THE COTTAGES AT MESA RIDGE GOODWIN KNIGHT EL PASO COUNTY, COLORADO

NOT FOR CONSTRUCTION SHEET L.01 1 PUD DEVELOPMENT PLAN LANDSCAPE COVER SHEET

Landscape Plan drawings_V1 redlines.pdf Markup Summary

GOODWIN KNIGHT logo
PUD/ PRELIMINARY PLAN
LANDSCAPE COVER SHEET
SHEET L.01 1

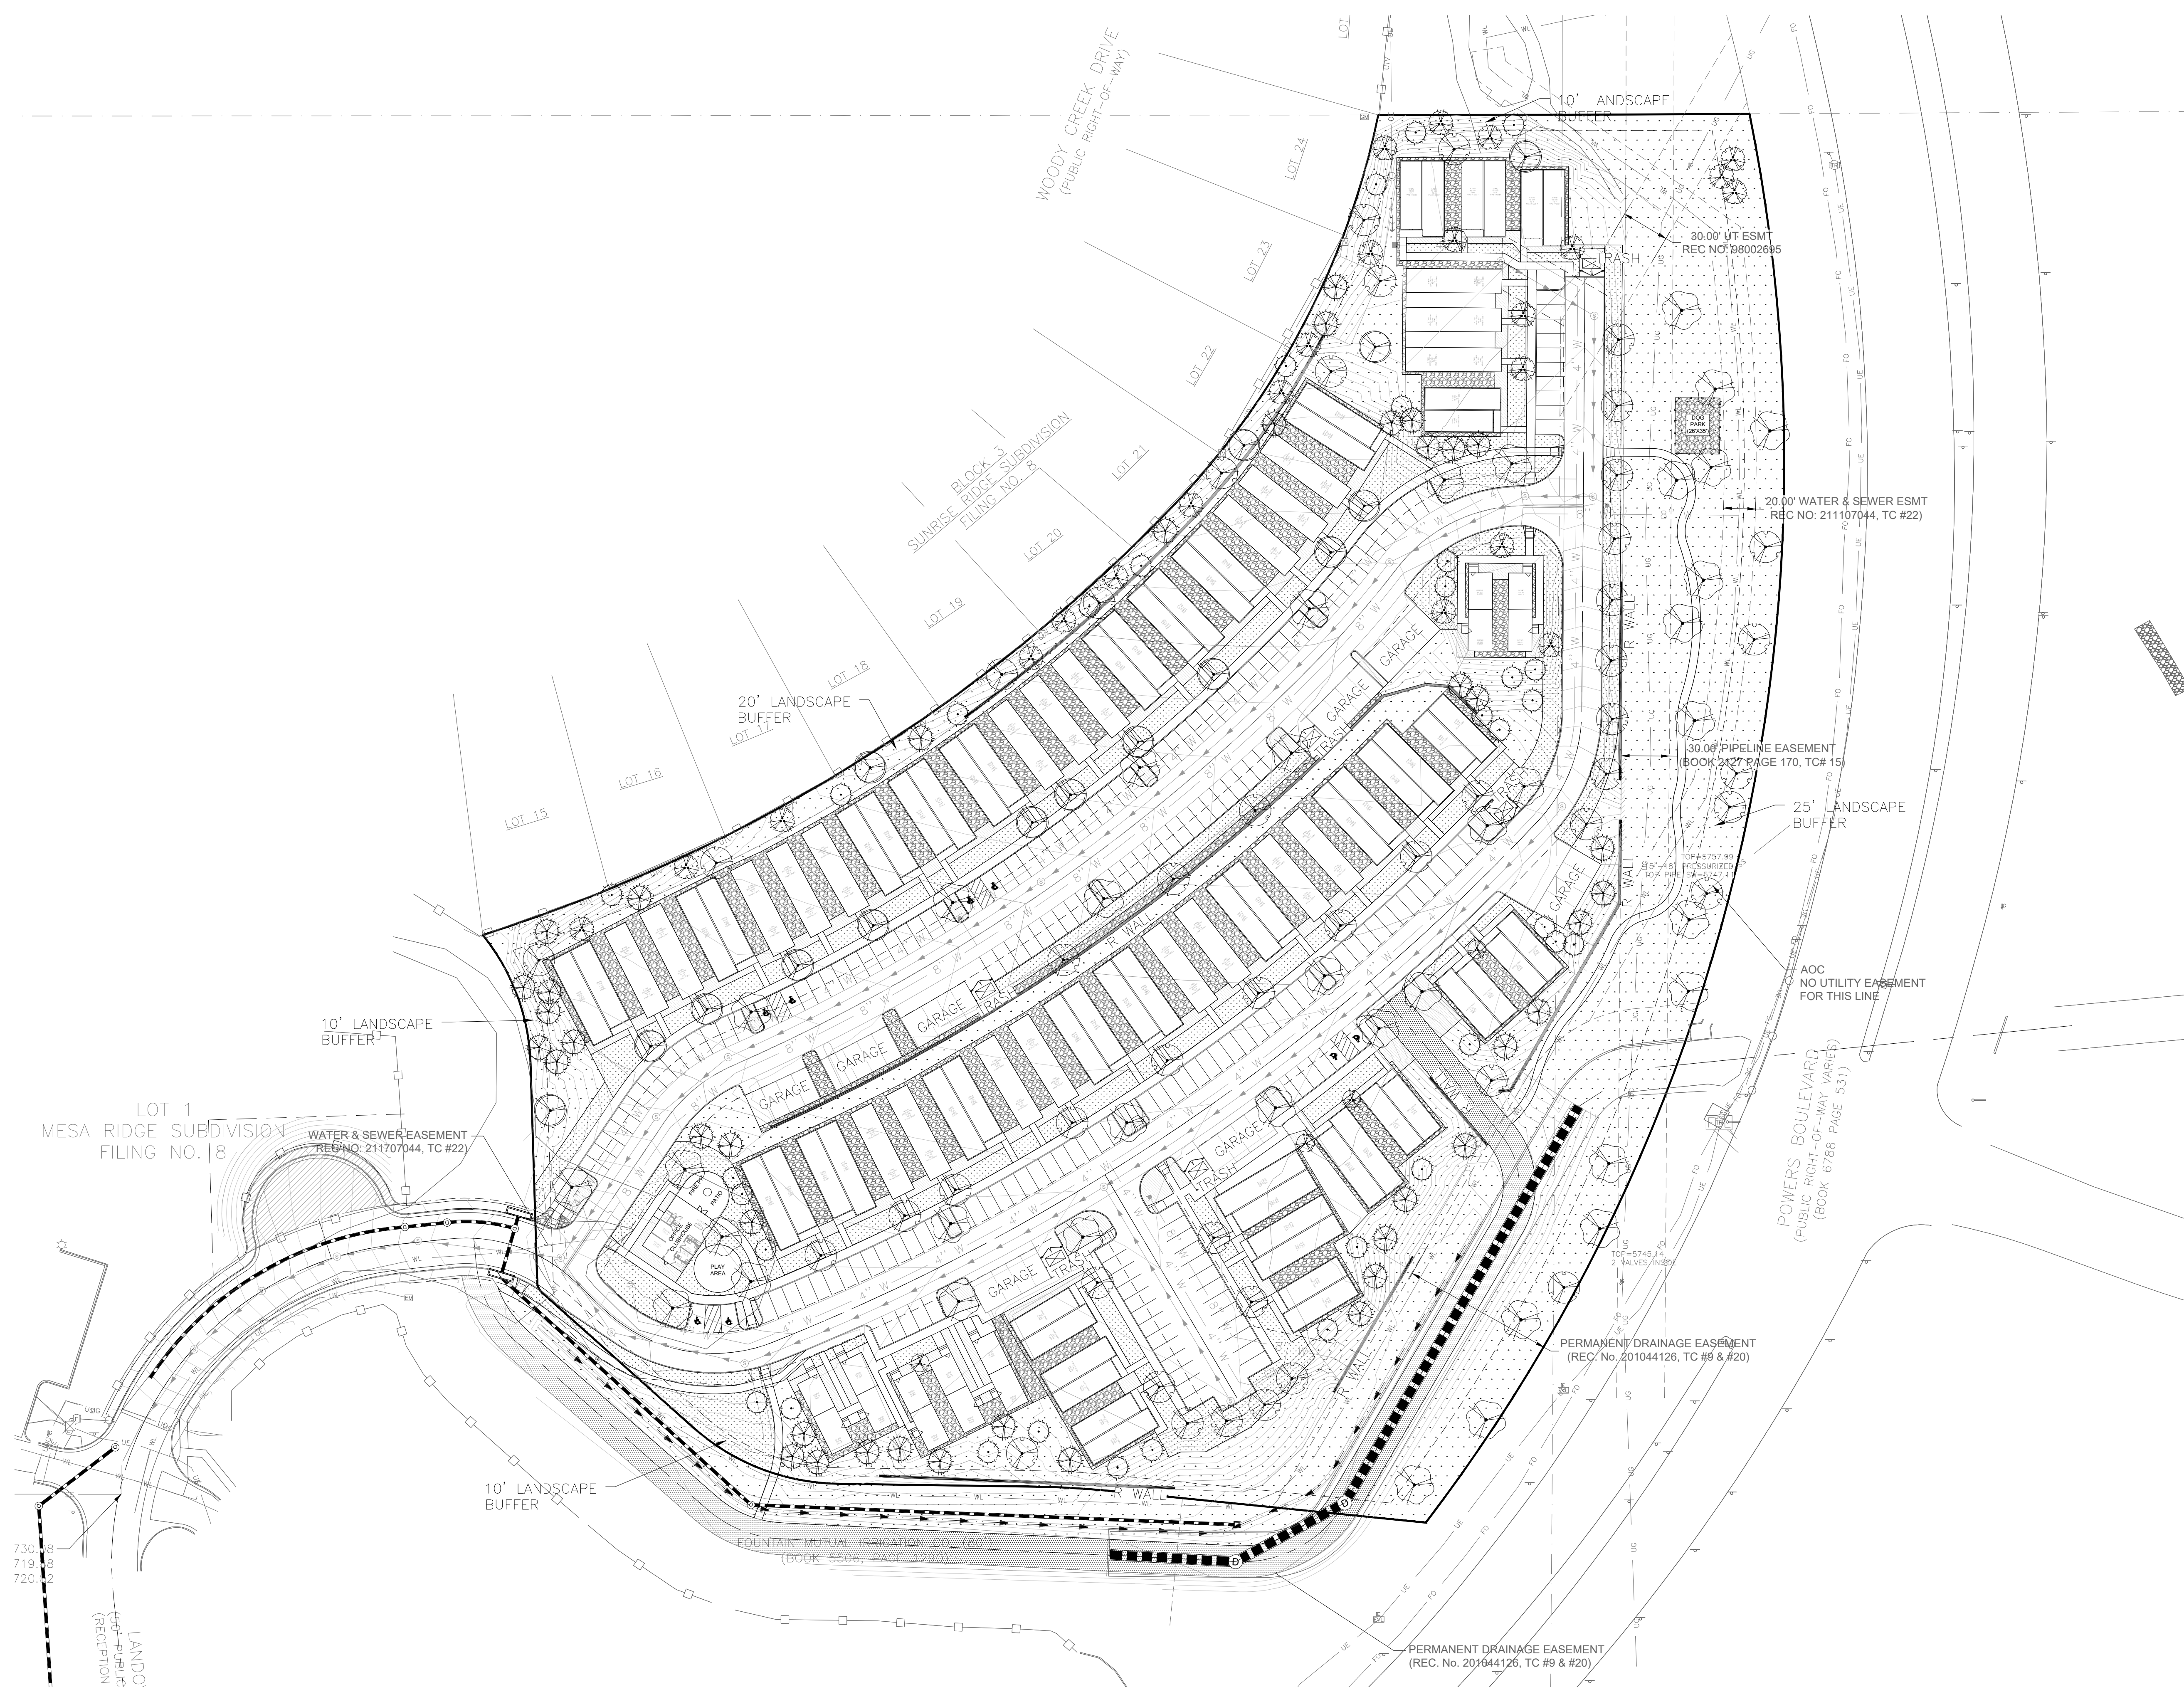
notes 10, 1 and 2 are basically same note

staff does not require irrigation plans just a statement; this is the PUD so the landscape plan is final

this is a PUD so landscape plan is final and recorded with the PUD

delete note County is not accepting any internal roads, walks, or improvements

County is public ROW owner but will not maintain landscape

County does not review irrigation plans

what is the evergreen shrub symbol? deciduous shrub symbol?

CA -20 count

grass and perennial symbol or Cloud with key on plan

no ordinance - Chapter 6 Code

add all items from checklist for landscape plan (road names, sidewalk labels, bldg & landscape setbacks, buffer lines and labels) among other missing items items

Verify 9 and 10 are accurate and complete on tables and legends. Staff will upload the checklist also. Since this is recorded with the PUD, the vicinity map is not needed as the LS will be sheets 7 and 8 of the PUDSP set.
